Upper Lachlan Shire Council

28 October 2025

Preliminary Submission on DA1-01-2000-Mod-3 Barina Quarry 2692 Collector Road NSW 2581

Figure 14: Austroads Guide to Road Design Part 4: Intersections and Crossings: General Figure 7.4

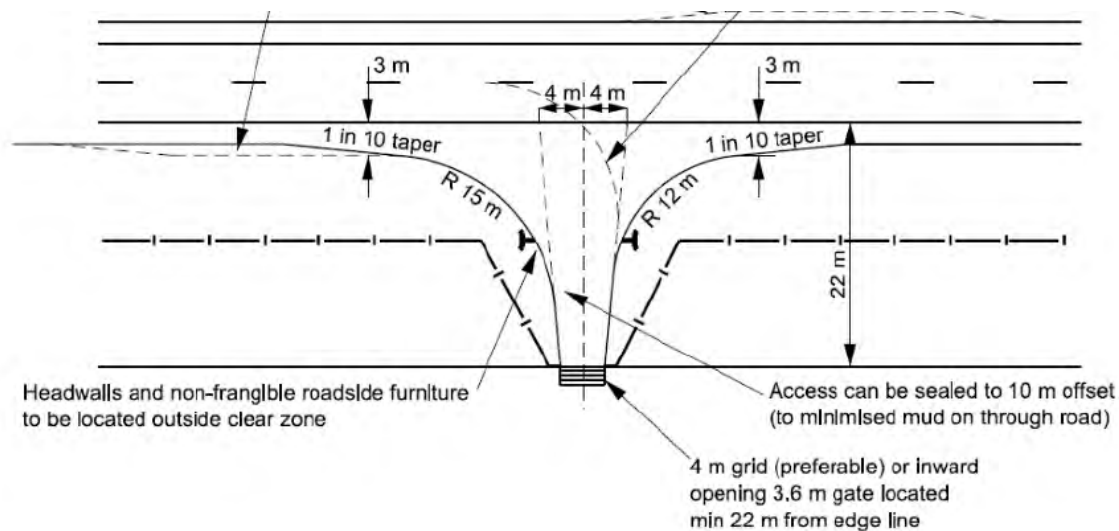
The Modification Report states that there are to be no changes to the existing site access, However, Figure 14 of Austroads Guide to Road Design Part 4: Intersection and Crossings, requires the access to be upgraded to a bitumen seal. Council officers recommend that this requirement be included as a condition of consent.
